Bulletin

Project Name: Ocean Gateway
Project No: 203438.11

Bulletin No: 33
Date of Issue: 8-04-2006

FIGURE II - 19
TYPICAL HOUSE LATERAL WYE CONNECTION DETAIL

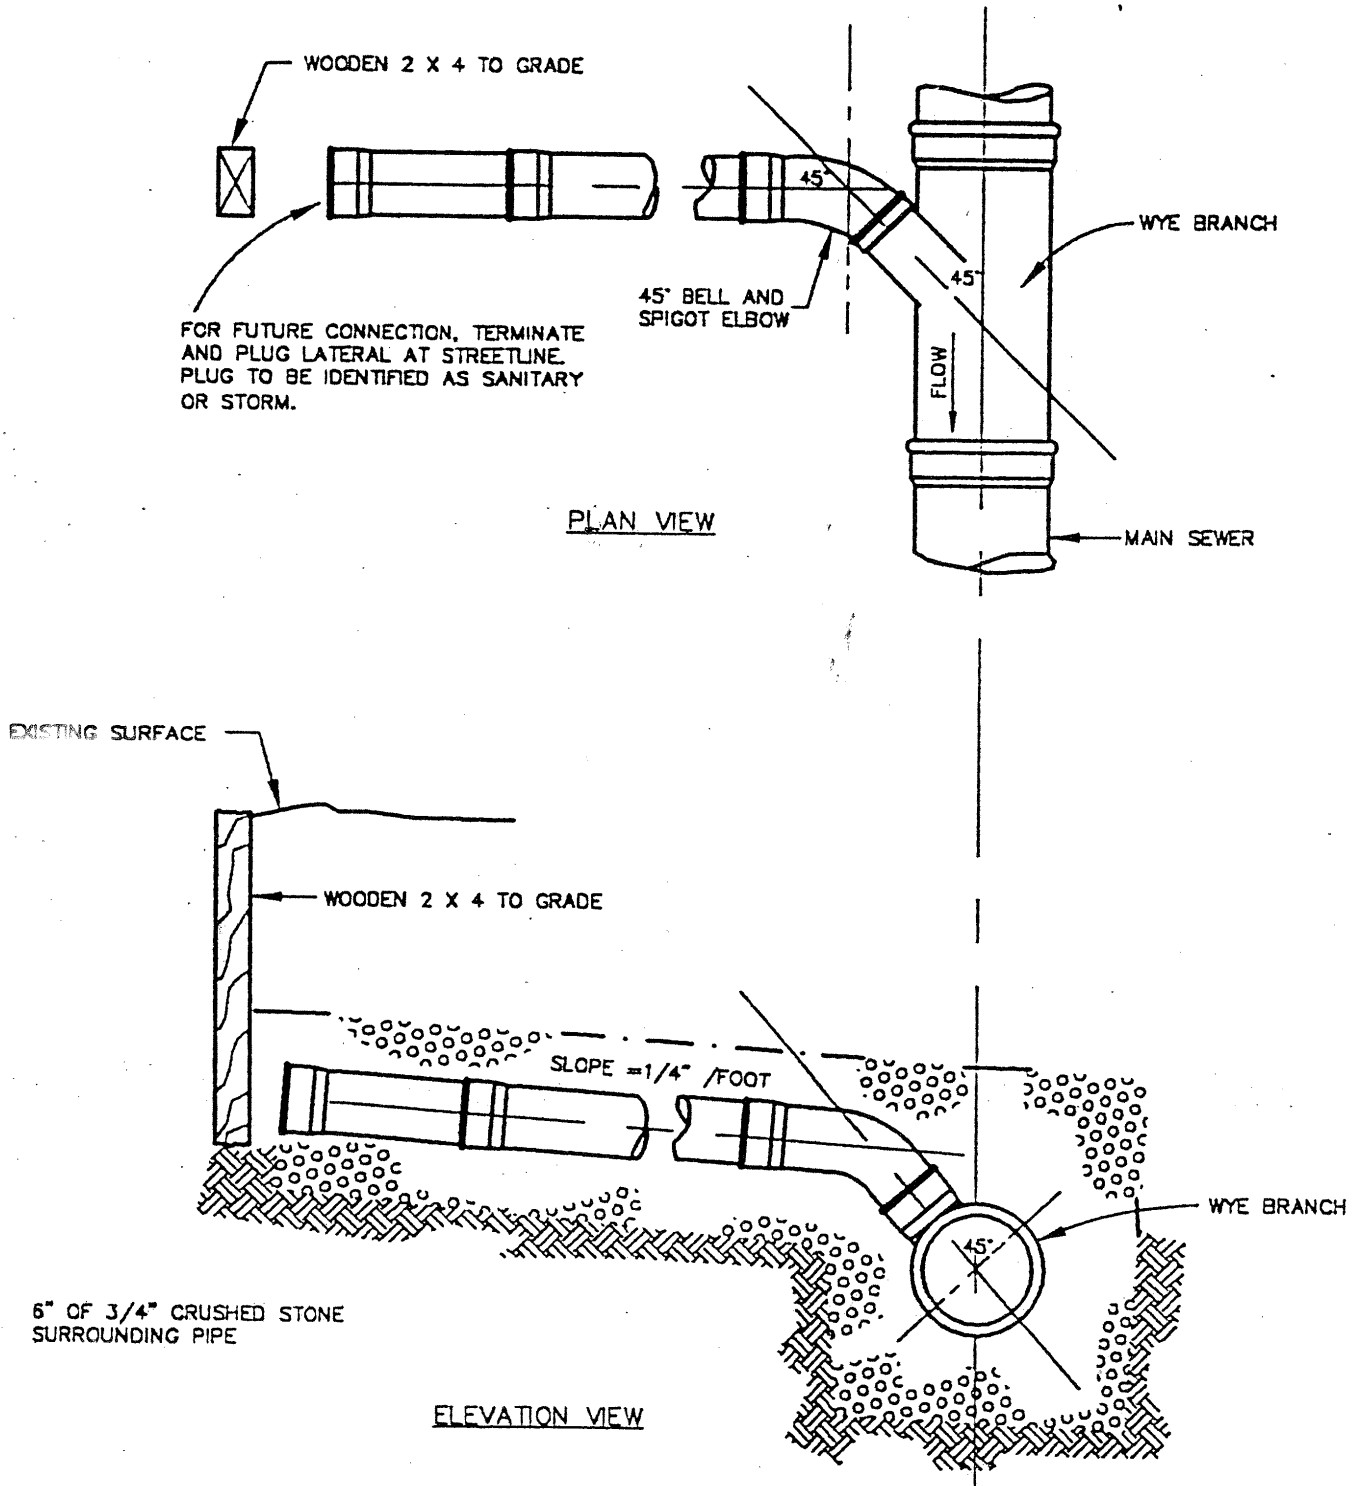
Description: Discussions between MDOT, Reed & Reed, the City of Portland and the developer of The Longfellow project have taken place over the course of the past several months. The consensus of the group was to develop sketches of building utility services and revisions to curbing along Commercial and Hancock Streets that are a result of The Longfellow Project for pricing. Utility services will be stubbed out to the locations depicted on the attached sketches to avoid future excavation within the streets. We have been unable at this time to get proper guidance from the electrical and communications companies with regard to service locations and loads, but we plan to pass this information along as soon as it becomes available. We realize that water, sewer and drain main lines are installed, or are being installed at this time, so we do not want to hesitate to submit these sketches for pricing.

Please review the attached sketches and prepare a cost proposal to perform the additional work. The cost of the additional work will be borne on The Longfellow Project, therefore the Cost Proposal shall be addressed to:

Attachments: Sketch SK-C007 – LONGFELLOW UTILITY SERVICES COMMERCIAL ST
Sketch SK-C008 – LONGFELLOW UTILITY SERVICES HANCOCK ST
Sketch SK-C009 – LONGFELLOW CURB LAYOUT PLAN COMMERCIAL ST
Sketch SK-C010 – LONGFELLOW CURB LAYOUT PLAN HANCOCK ST
City of Portland Standard Detail – Wye Connection
